KITTITAS COUNTY
DEPARTMENT OF PUBLIC WORKS

MEMORANDUM

TO: Trudie Pettit, Community Development Services
FROM: Christina Wollman, Planner II *CW*
DATE: September 26, 2008
SUBJECT: Monahan Mountain Tree Farm Tracts Large Lot Subdivision LL-08-05

LL-08-05

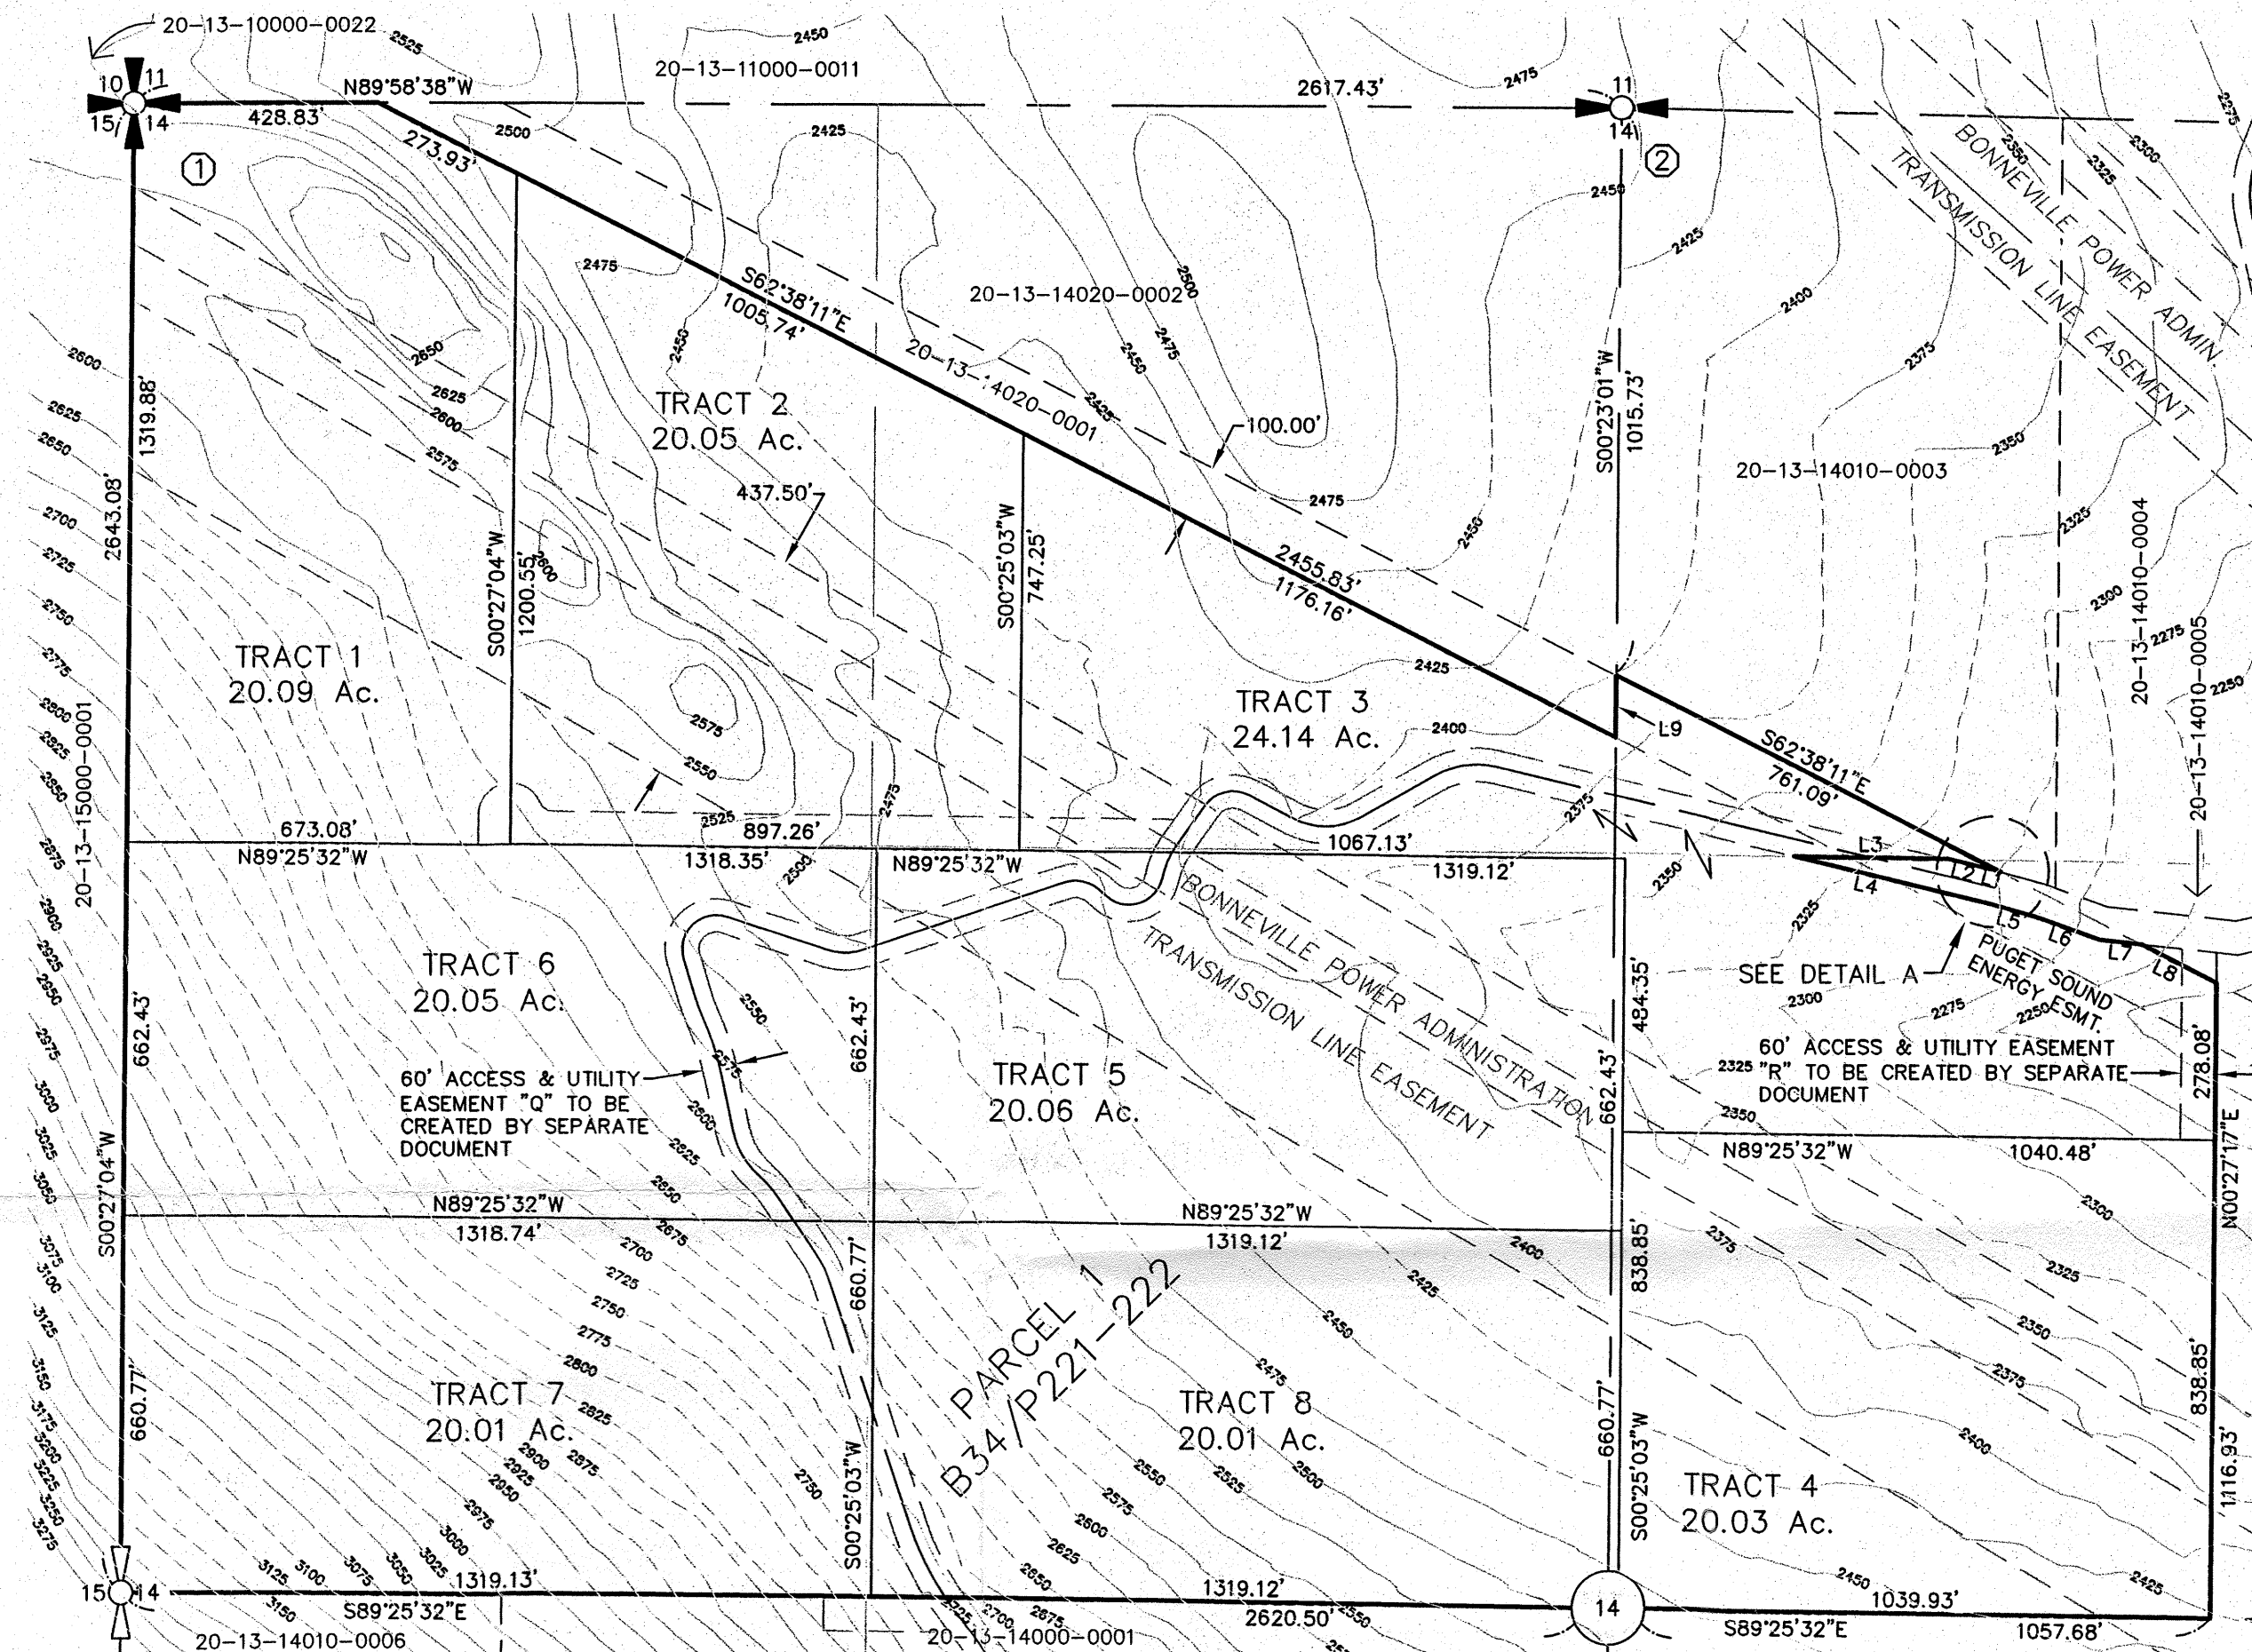
2. **Site Distance:** The access with Cabin Creek Road shall be improved to meet site distance if necessary. Site distance shall be included in the road certification

5. **Tract 1 & 2 Access:** The easement to Tract 1 & 2 shall be described on the final plat.
6. **Certificate of Title:** The certificate of title shall be submitted prior to receiving final approval.

7. **Private Road Improvements:** Access from Cabin Creek Road to the cul-de-sacs shall be constructed as a Low-Density Private Road. See Kittitas County Road Standards, 9/6/05 edition.

- a. Access easements shall be a minimum of 60' wide. The roadway shall have a minimum width of 20', with 1' shoulders, for a total width of 22'.
 - b. Minimum centerline radius will be 60'.

- c. The surface requirement is for a minimum gravel surface depth of 6".
 - d. Maximum grade is 12%.
 - e. Stopping site distance, reference AASHTO.
 - f. Entering site distance, reference AASHTO.

- j. All easements shall provide for AASHTO radius at the intersection of county road.
 - k. A paved apron shall be constructed at the intersection of the proposed private intersection and the county road right of way.

8. Cul-de-Sac: A cul-de-sac turn-around having an outside right-of-way easement diameter of at least 110 feet shall be constructed at the closed end of all dead-end roads serving 3 or more lots. The driving surface shall be at least 96 feet in diameter. Cul-de-sacs must also conform to the requirements specified by the 2006 International Fire Code. Contact the Fire Marshal regarding any additional cul-de-sac requirements.
